From: Simon Davis
Sent: 24 April 2017 14:26
To: Planning.Responses
Subject: FW: AL/23/17/DOC - Land at Aldingbourne Farm Shop, Nyton Road

From: Rachel Alderson
Sent: 24 April 2017 14:24
To: Simon Davis
Subject: AL/23/17/DOC - Land at Aldingbourne Farm Shop, Nyton Road

Tree and Hedge Planting

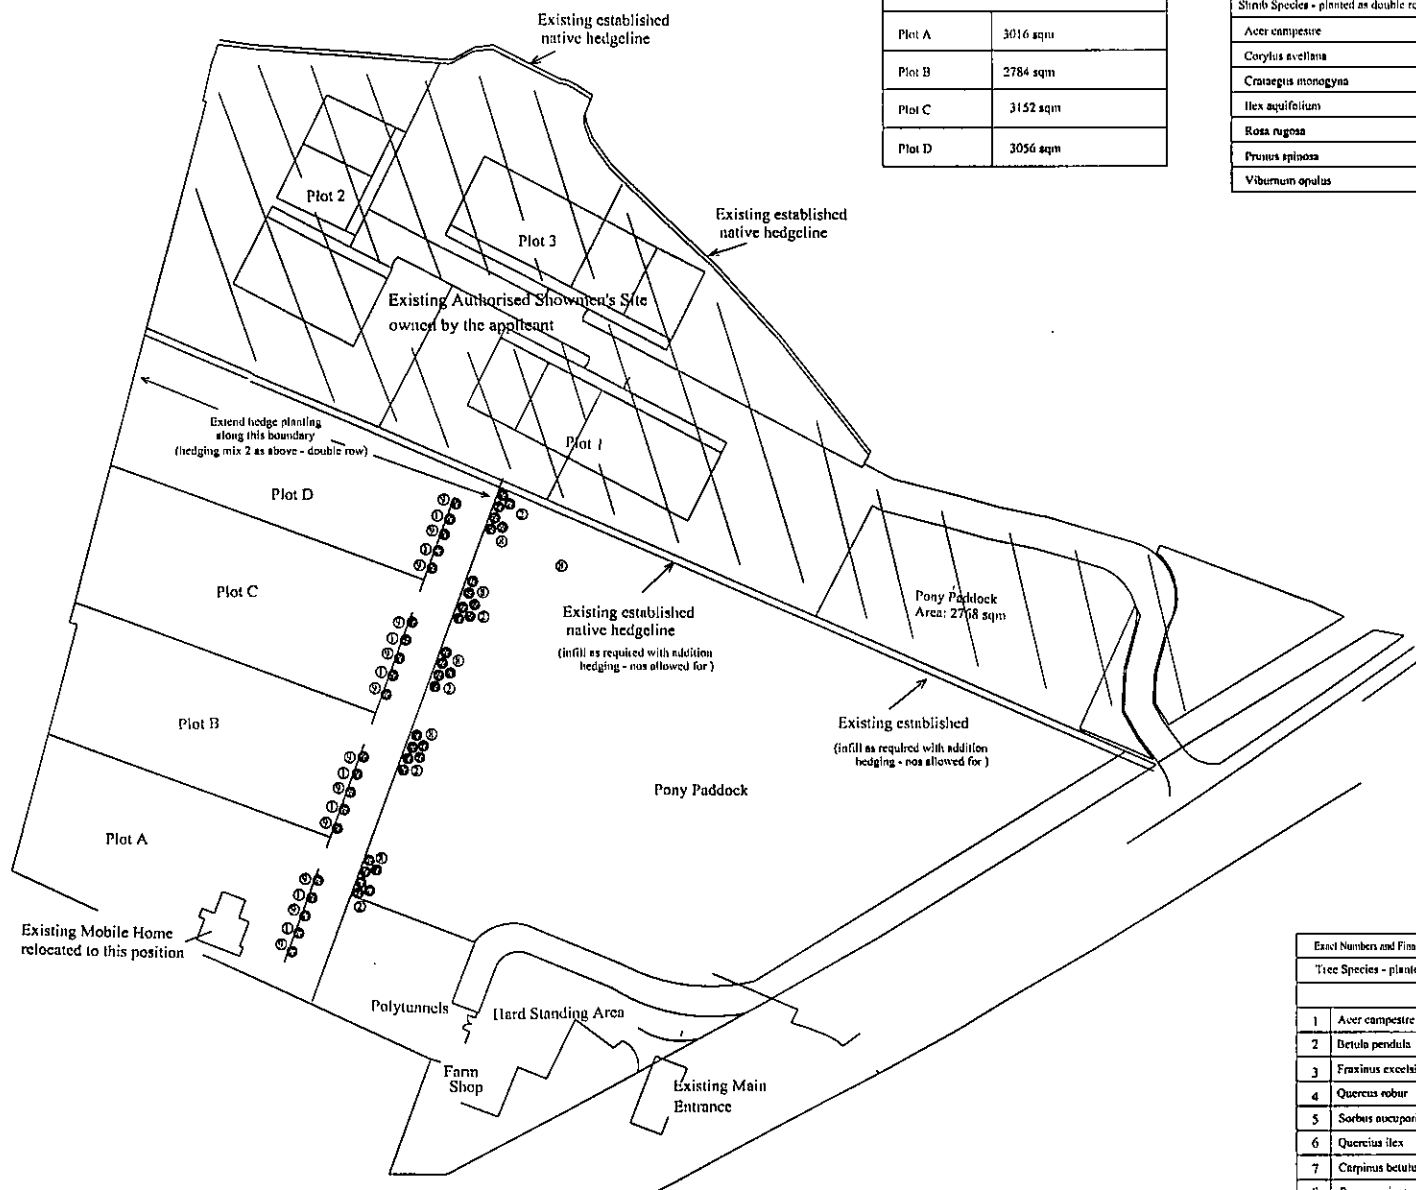
Apologies, I have only just had sight of the landscape plan submitted for the above application. I met the applicant and agent on site in November 2015 to discuss the planting requirements for this site. While the site is mostly screened from external views there are gaps which need to be filled, particularly from the adjacent footpath. The plan submitted appears to fulfil this need and gives outline details of the suggested planting, however I require a fully detailed planting plan to be able to provide meaningful comment, particularly relating to the locations of the standard trees. I would also ask for standard trees to be incorporated along the hedge line adjacent to Plot D.
